**ADC Planning Consultation
Conservation/Design Officer Response**

Application Number	A/75/17/PL
Address	Avenals Farm Water Lane Angmering BN16 4EP
Description	4 No. dwellings. This application affects the setting of a Listed Building & is a Departure from the Development Plan.
Case Officer	Mr D Easton
Date	22 November 2017

PROPOSED
GROUND FLOOR
PLAN SCALE 1:100

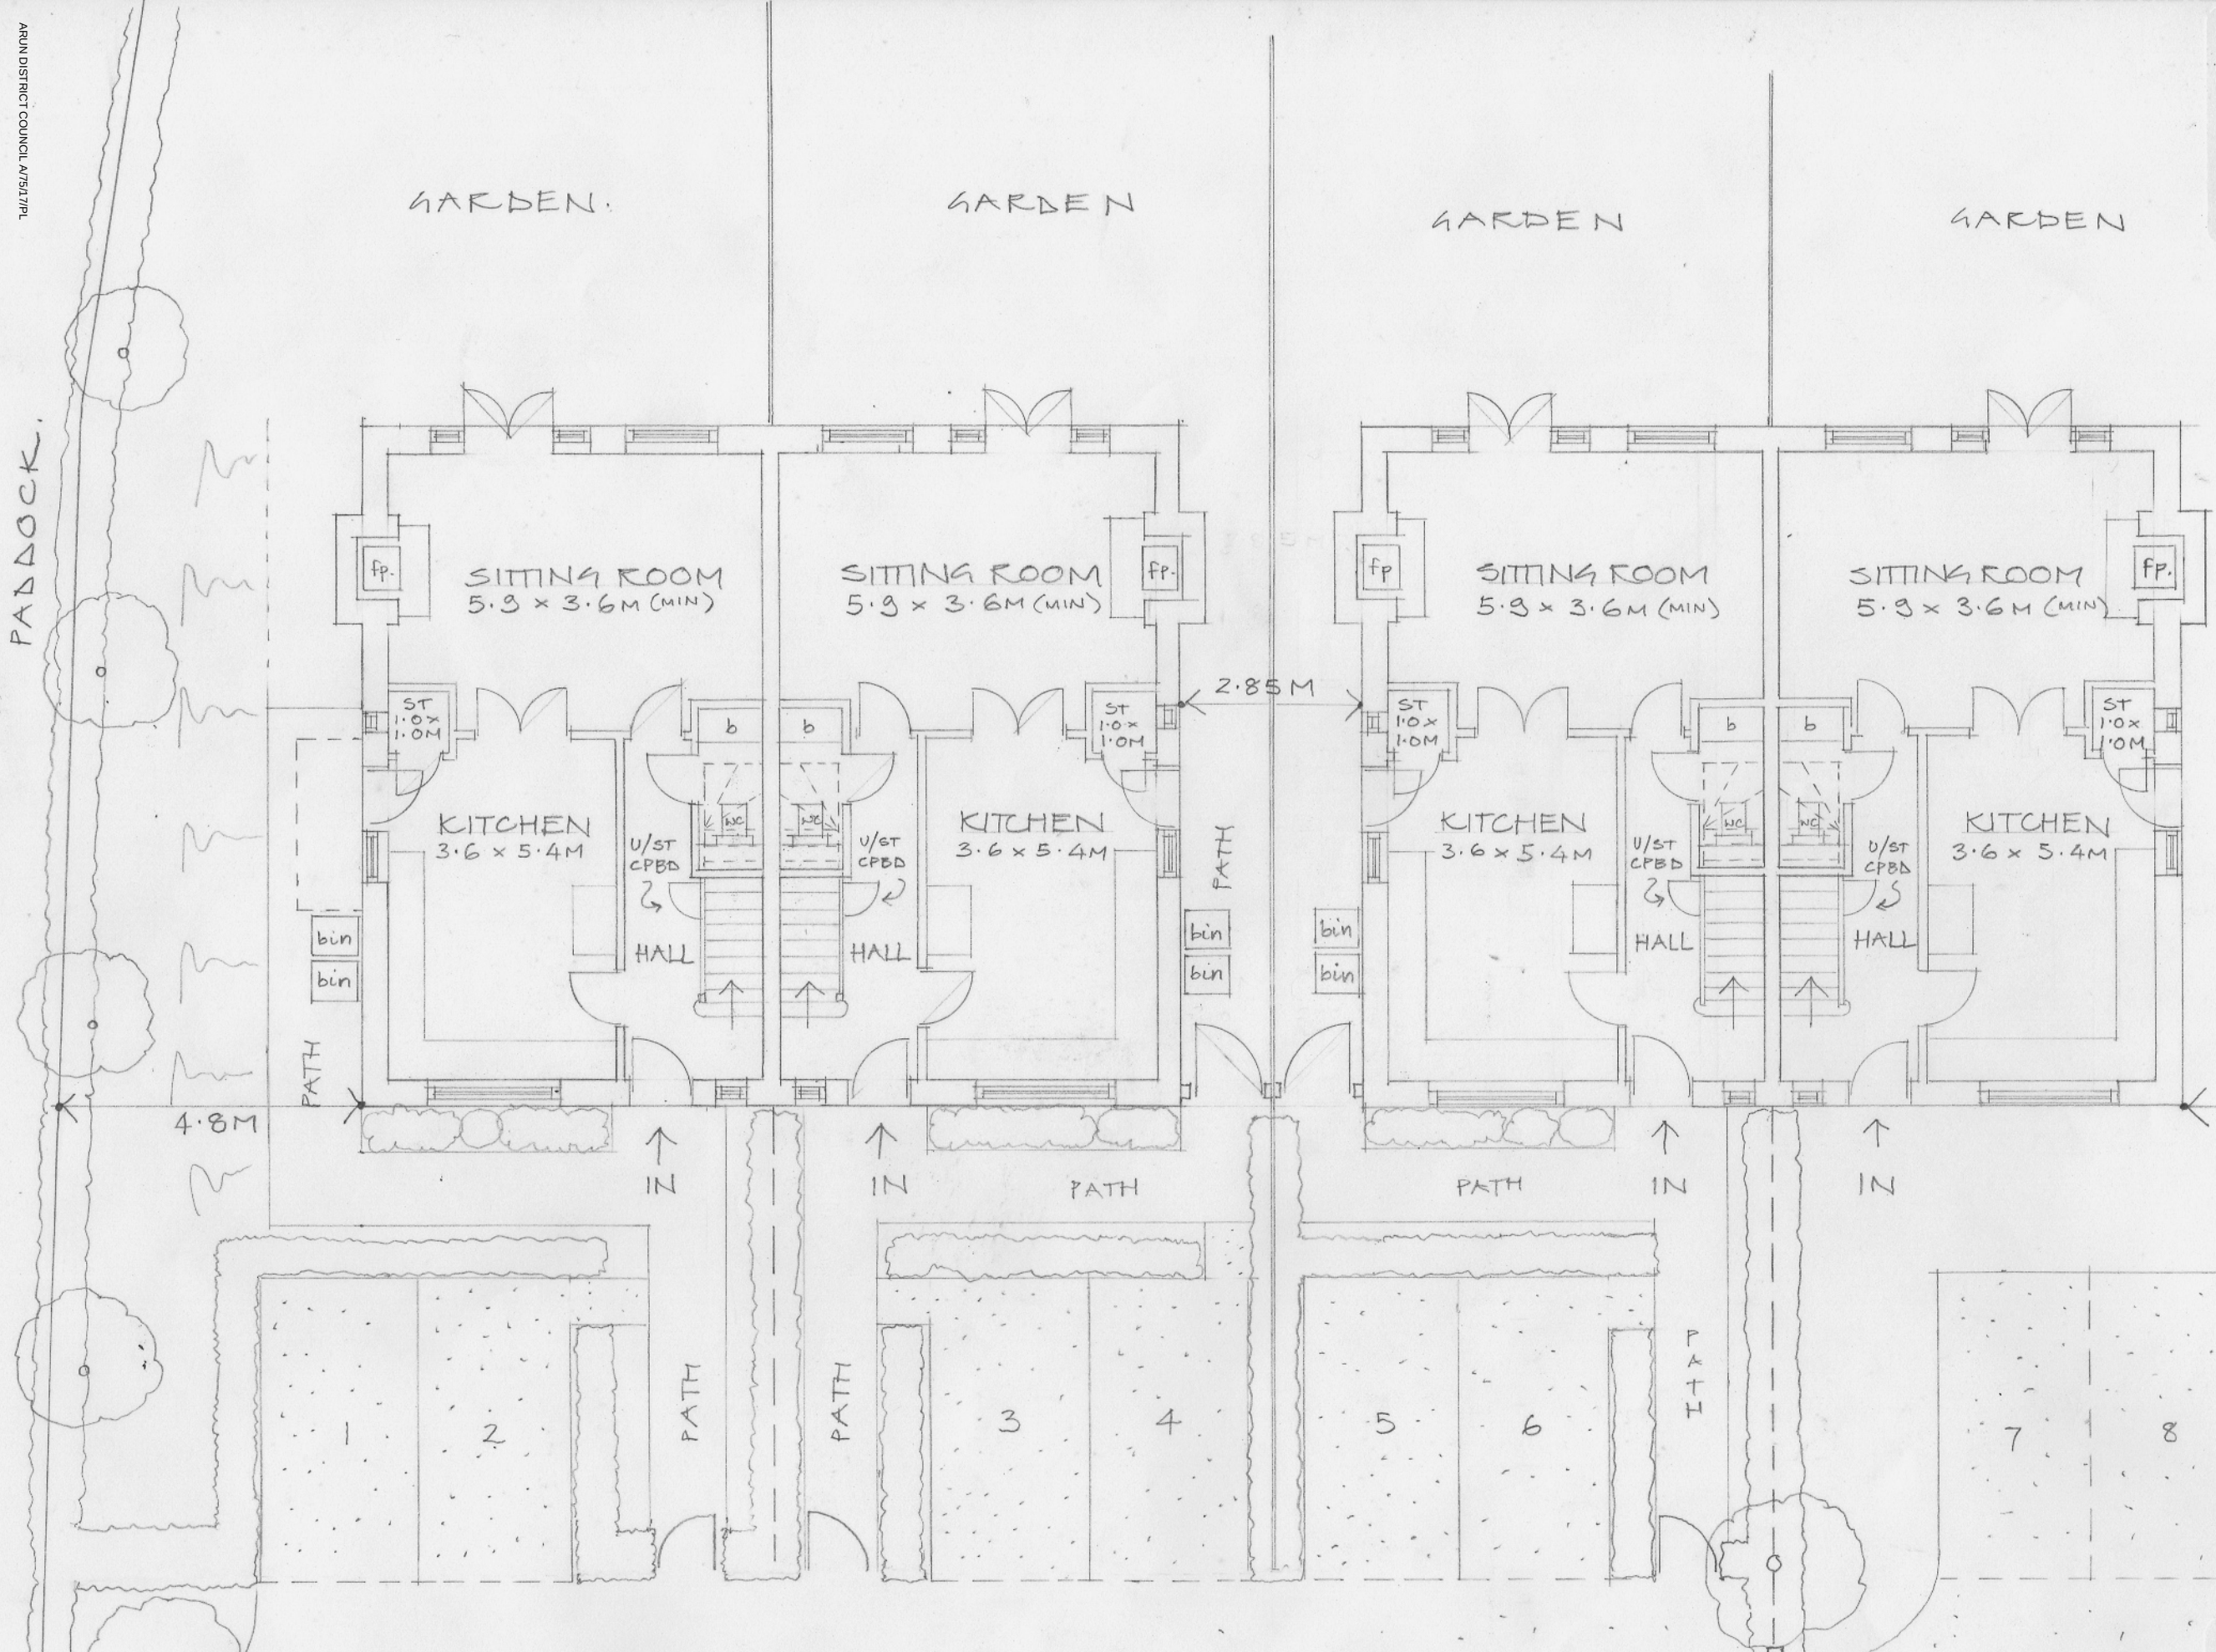
While there is no objection to the material palette of the proposed scheme, the houses are somewhat incongruous with the rural setting, being more village-urban in feel, being more suited to a 'edge of village setting' in aesthetic, massing and in the relationship the pairs of dwellings have with one another. That said, it is noted that an application for 175no. residential dwellings under which if Planning Permission were granted, would affect the generally rural nature of the setting of the Listed Asset and make the proposed scheme seem less at odds with prevailing conditions.

It is entirely possible that scheme [A/99/17/OUT](#) be refused Planning Permission, or that there be delay in construction, and therefore the retention of a generally agricultural setting of these cottages be maintained by minimal hard landscaping/hardstanding, and by the use of visually permeable boundary treatments such as post and rail, five bar gates were required so a connection with the wider landscape is retained both into and out of the existing heritage asset.

It is therefore recommended that the scheme be recommended for approval on heritage grounds, subject to condition of material finishes to the properties, their boundary treatments and hard-landscaping.

PROPOSED SOUTH ELEVATION SCALE 1:100 AT A3.

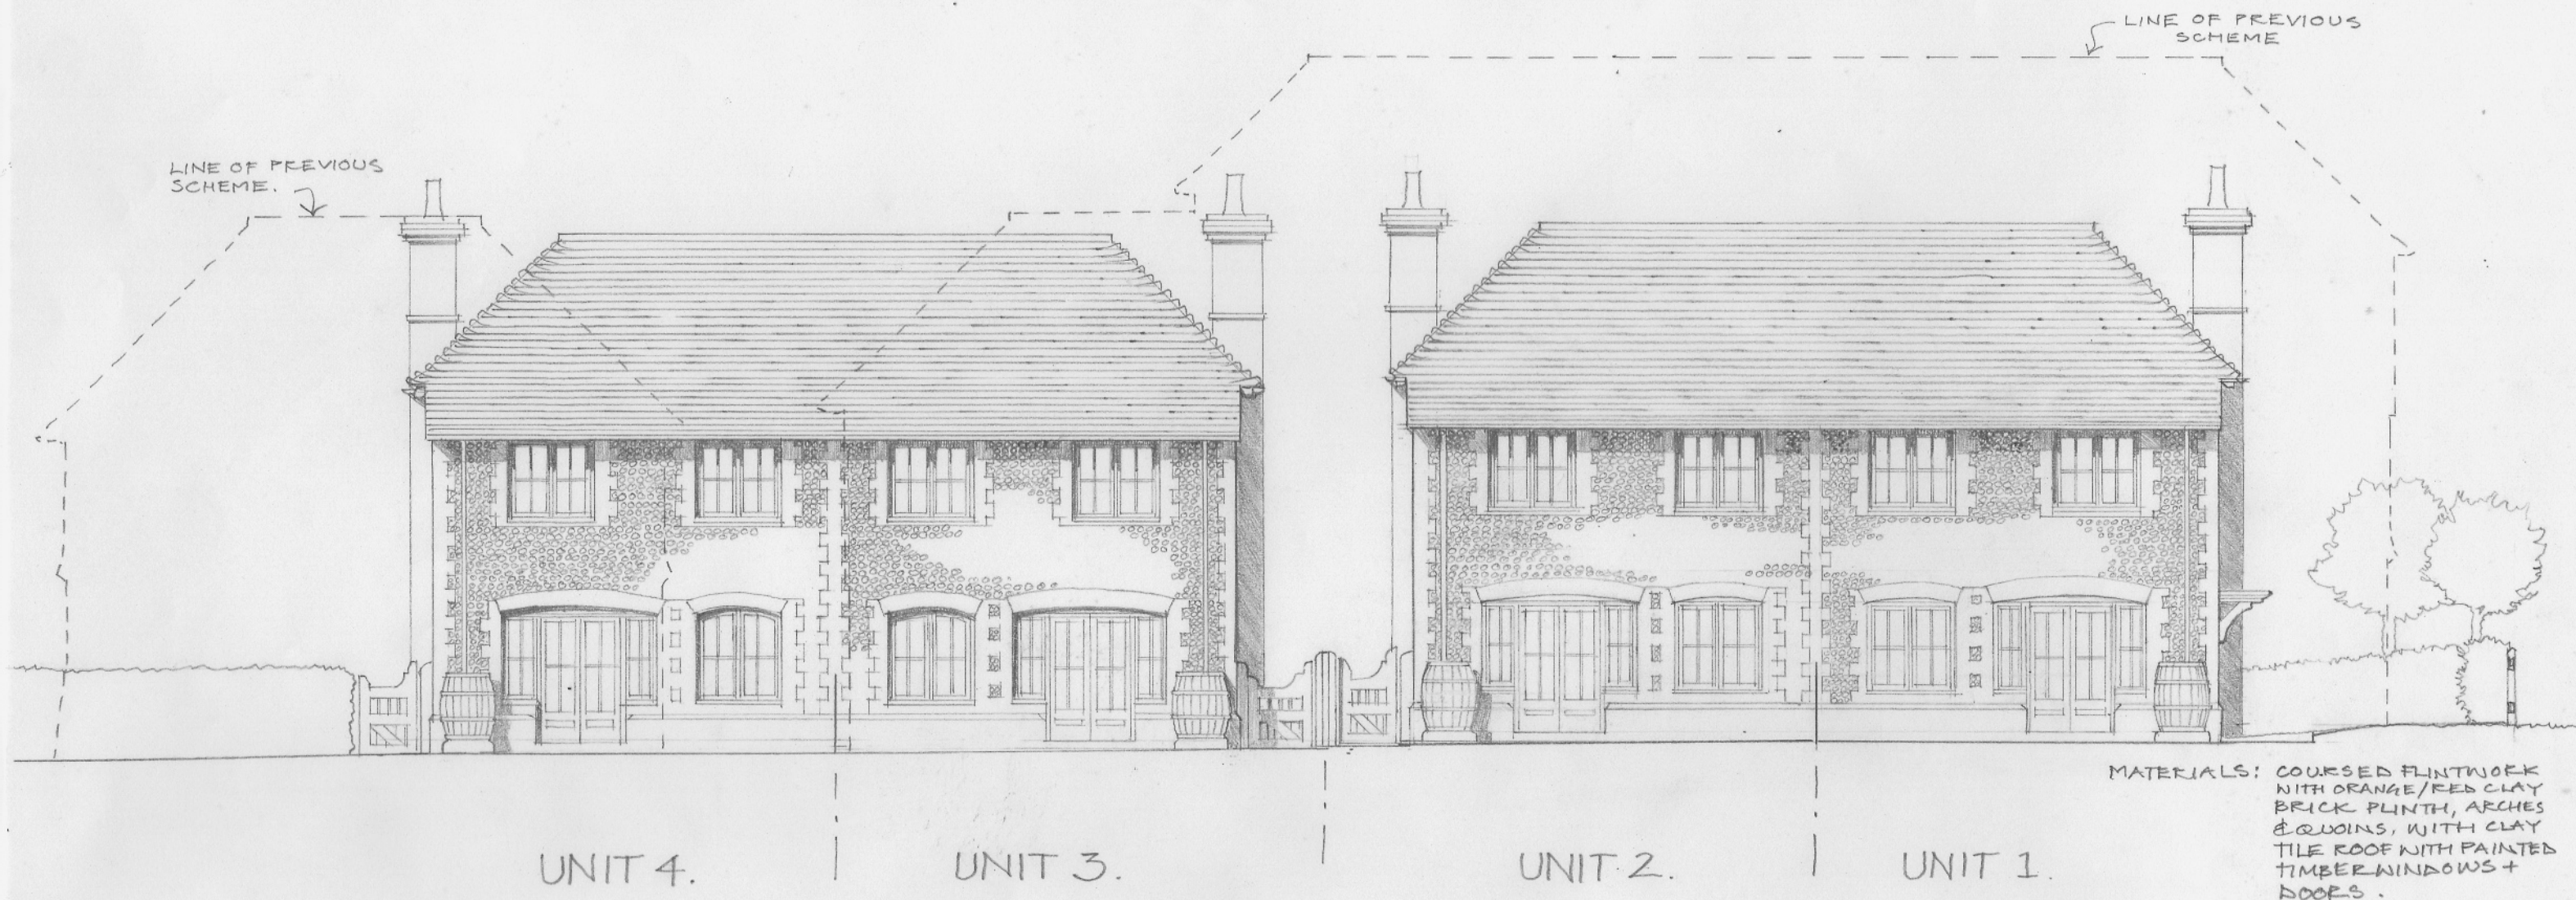
The submitted amended designs for 4no dwellings is much reduced in height from 11,000mm to 8,000mm ridge height. The overall massing of the proposal has been reduced by virtue of removal of the 5th property. The revised scheme now reads as two pairs of semi-detached houses.
